12 February 2021

**RE: ASPECT INDUSTRIAL ESTATE (AIE), KEMPS CREEK (SSD-10448): RESPONSE TO SUBMISSION
CIVIL ENGINEERING COMMENTS**

Pursuant to the Response to Submission (RTS) issued by Department of Planning Industry and Environment (DPIE) on the 22nd of December 2020 for the Aspect Industrial Estate SSD DA (SSD-10448), we have provided responses to the submissions and comments relating to the civil engineering design and documentation for the development.

Civil Engineers and Project Managers		Level 7, 153 Walker Street North Sydney NSW 2060 ABN 96 130 882 405 Tel: 02 9439 1777 Fax: 02 9923 1055 www.atl.net.au info@atl.net.au
Status	FOR APPROVAL NOT TO BE USED FOR CONSTRUCTION	A1
Project - Drawing No.	18-596-C1006	Issue C

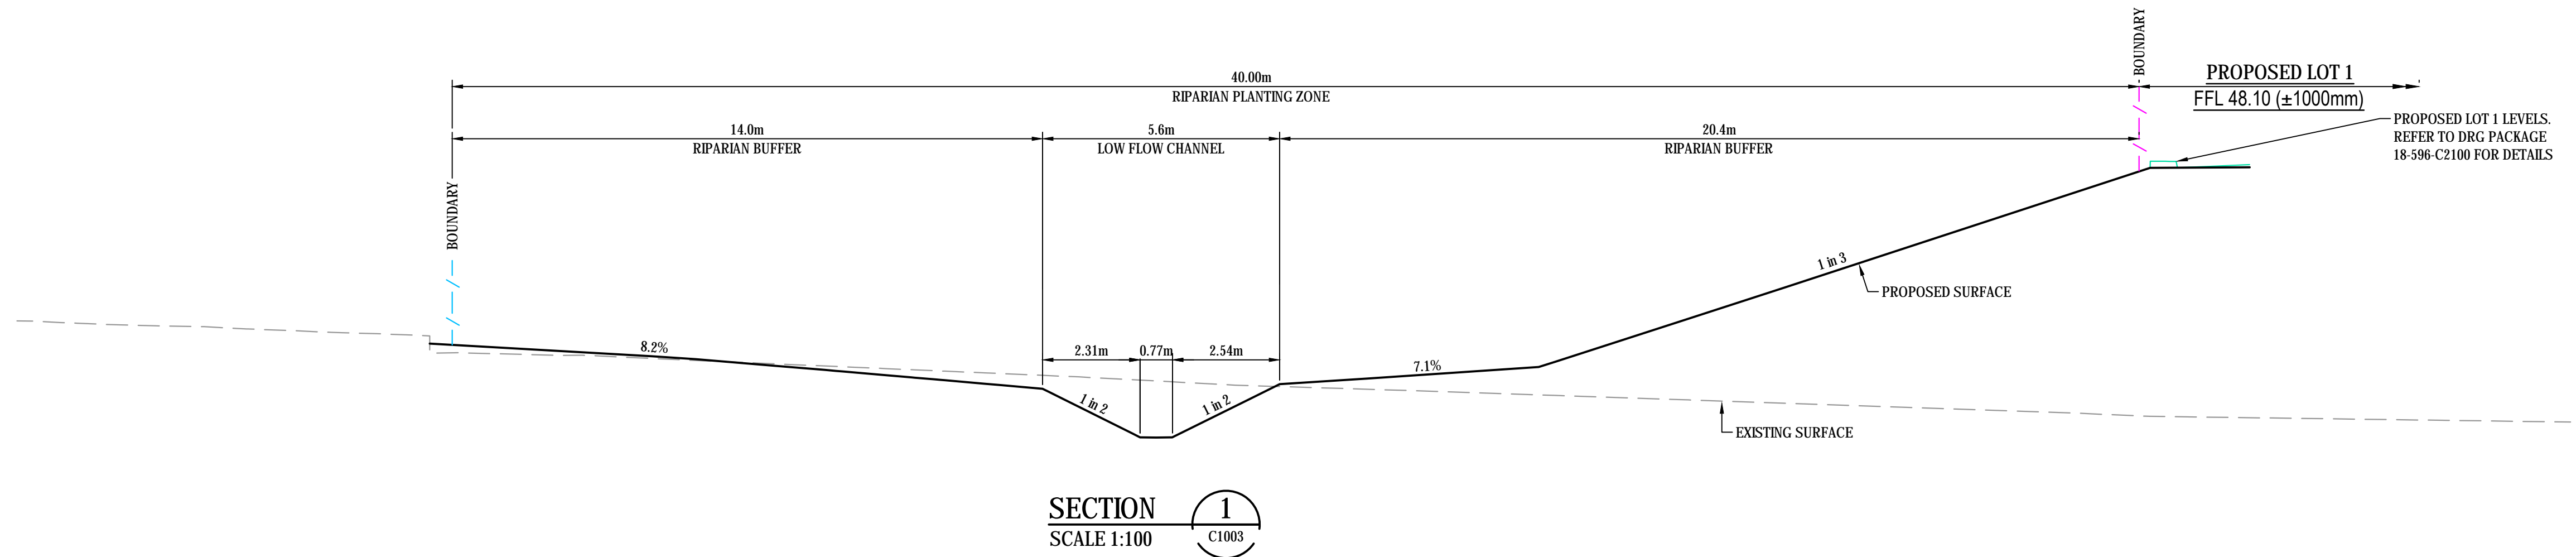
DPIE Comment - The Department notes the width of the proposed creek channel is inconsistent between documents. The Riparian Assessment Report states the channel would be 4.75 m wide, whereas Sections 1 and 2 in the Civil Drawing (No: 18-596-C1010) show the low-flow channel would be 5.6 m and 5.7 m wide respectively. Furthermore, the typical riparian corridor section in Civil Drawing (No: 18-596-C1006) shows a 3.75 m wide low-flow channel within a 20 m wide high flow channel. Please clarify the width of the channel.

AT&L Response – The low flow channel width varies due to the existing topography at the boundary and the proposed built form. The Riparian corridor section on Drawing 18-596 C1006 has been updated to suit (i.e., minimum 3.75m width low flow channel). The actual width varies between 3.75 and 5.7m.
